Listed building consent to replace 9 No. sash windows to south elevation.
Tower House London Road Arundel

Thank you for your internet representation made on 3rd September 2019 which has been recorded as '**no objection**' with the comments as follows:

South Elevation

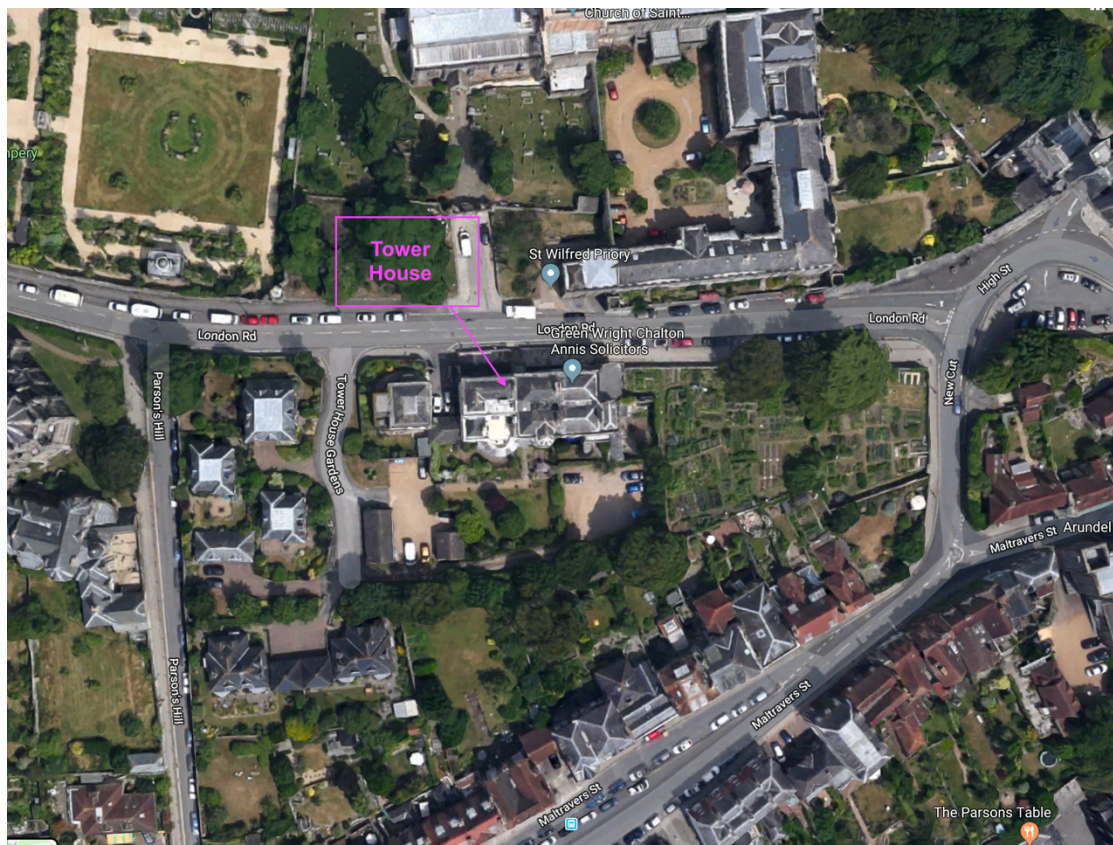
As such it is extremely important that the quality of these buildings and of the character area is not eroded by unsatisfactory alterations. The replacement of the sash windows on a strictly like for like basis will not impact on the appearance of the conservation area.

However, this comment is made on the basis that the Council is fully satisfied that the windows are beyond reasonable repair and that sufficient information has been submitted with the application to ensure exact like for like replacement in materials, design, appearance and operating mechanism. In addition, the Council should ensure that any old glass eg. cylinder or crown, is retained and re-used in the replacement windows.
